From: Gregg, Robert <Robert.Gregg@lancashire.gov.uk>
Sent: 15 January 2021 16:08
To: Laura Eastwood
Cc: Planning
Subject: D3.2020.1091 - Coars Farm Garden Centre, Settle Road, Bolton By Bowland.

In respect to the proposed redevelopment of site for 30 no. holiday chalets, conversion of existing holiday house and adjacent barn to a 20 person holiday let, extension of existing cafe, construction of reception building with managers flat, alteration to existing garden centre to form farm shop and plant display area, creation of car parking, landscaping and associated works, my initial comments would allow the applicant the opportunity to address the below raised issues and whilst I would raise no objection to the principle of the development proposal, I must ensure that the proposal would not be detrimental to highway users.

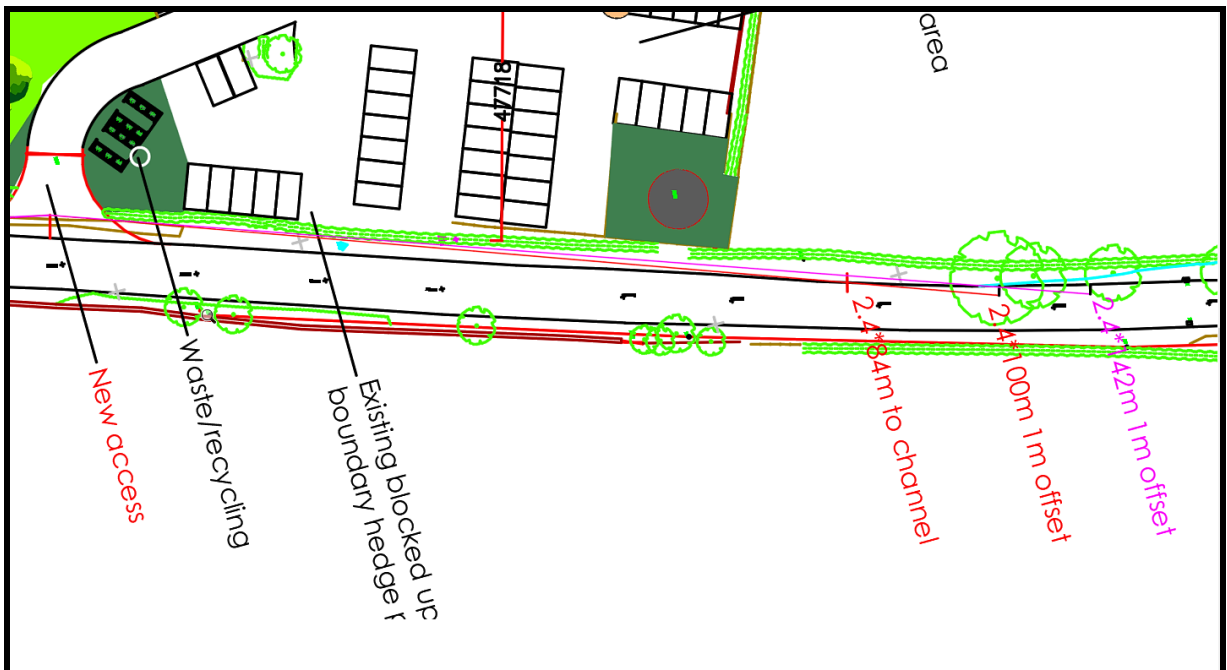
Visibility splays must be maximised and remain unobstructed in perpetuity of the development, the proposed repositioning of the existing access point will increase the existing visibility lines which would bring betterment to that of the existing arrangement. However the submitted transport statement states there is "no need to remove hedge as it is not required" although any obstruction of the visibility splays will need to be removed for the lifetime of the development and maximisation of the visibility splays by setting back some of the hedge fronting the development site must be explored to see if Visibility splays at the development sight have reached their full potential.

However, with that being said with current traffic speeds in some areas being considered as slightly higher than the pre-Covid era due to less trafficked roads, officer discretion could be applied to a speed survey being carried out with total disregard to any volumetric data, purely looking at the speed data to determine visibility splays and therefore using traffic counts for speed to determine visibility splays would be considered acceptable. The ATC carried out on site has provided 85%ile speeds of 41mph and 48.7mph, this data has been provided by the appointed transport consultant and from this data visibility splays for an absolute minimum of 85m to the left and 111m to the right have been suggested, as previously stated these figures would bring betterment to that of the existing arrangement however maximisation should be explored here.
